Our ref: HA/2021/123510/01-L01
Your ref: LU/251/21/PL
Date: 09 September 2021

PARTIAL DEMOLITION OF NUMBER 57 RIVER ROAD, CHANGE OF USE & REDEVELOPMENT TO PROVIDE A FLATTED DEVELOPMENT COMPRISING 6 NO APARTMENTS, WITH PRIVATE AMENITY SPACE, PARKING & CYCLE STORAGE. INCLUDING THE PARTIAL DEMOLITION OF THE ADJACENT BOUNDARY WALL TO PROVIDE A NEW PEDESTRIAN ACCESS & THE CREATION OF A FLOATING PONTOON WITH RESIDENT MORNING SPACES (RESUBMISSION FOLLOWING LU/247/21/PL)

57 RIVER ROAD LITTLEHAMPTON BN17 5DD

Environment Agency Position

TITLE: PROPOSED SOUTH EAST ELEVATION

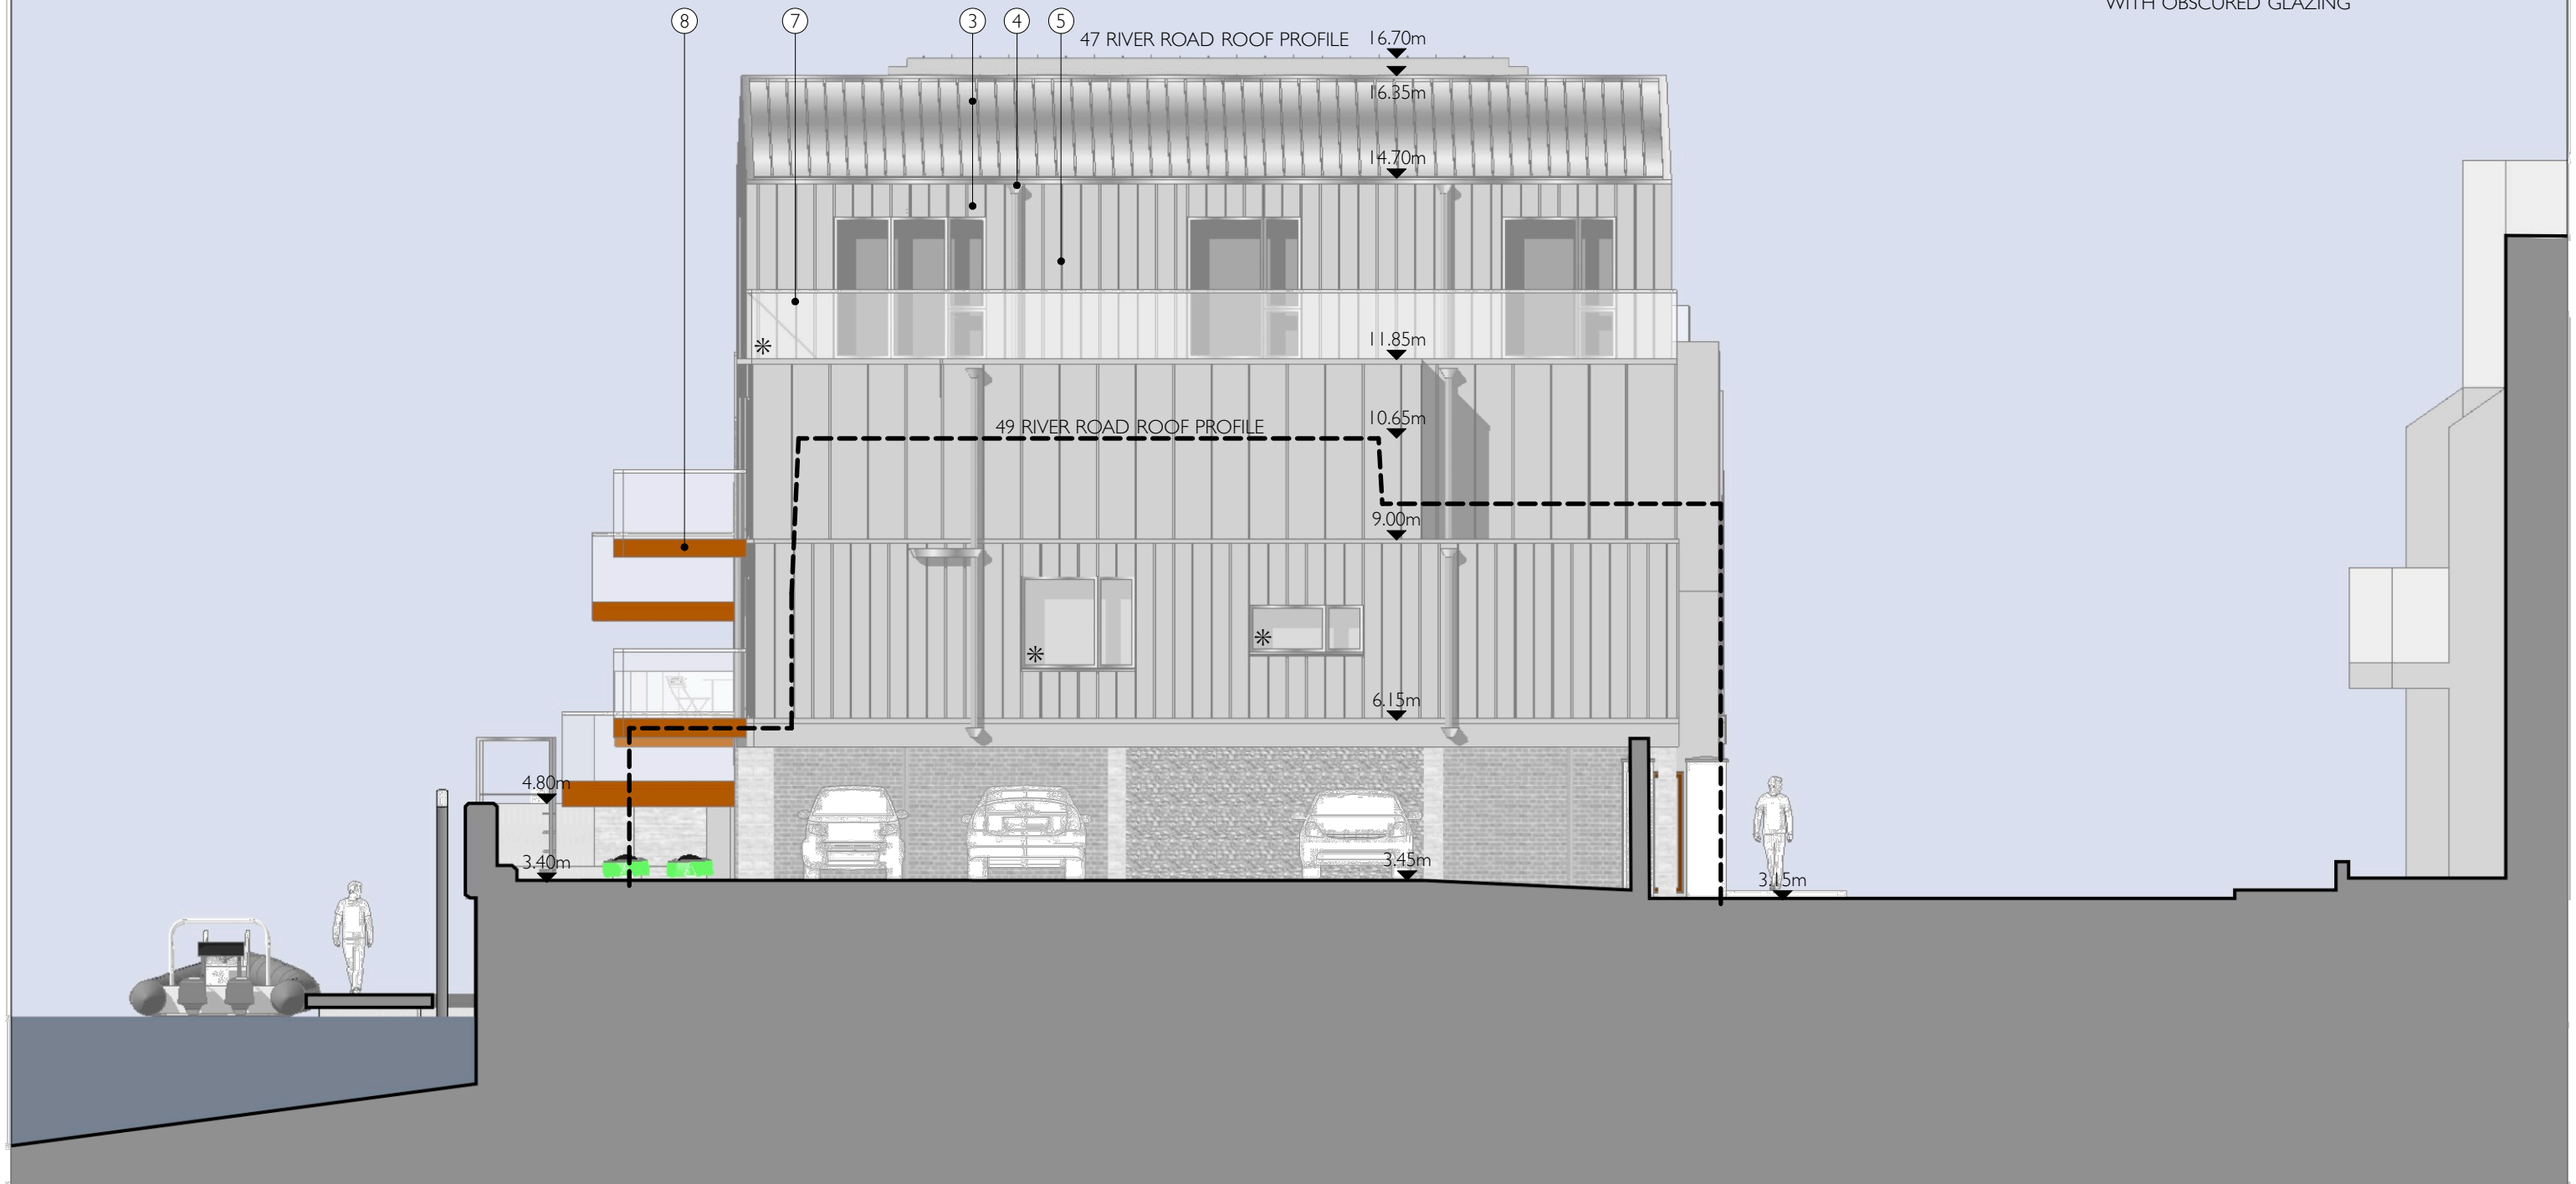
- The Ground Floor Finished Floor level of the development must be set no lower than 5.17mAOD

Providing all the finished floor levels are set no lower than 5.17mAOD, the development is likely to remain free of inundation over its lifetime. Safe refuge is available within the building. The LPA should be satisfied that the building can remain structurally sound given the potential flood depths (1.47m) possible at the site.
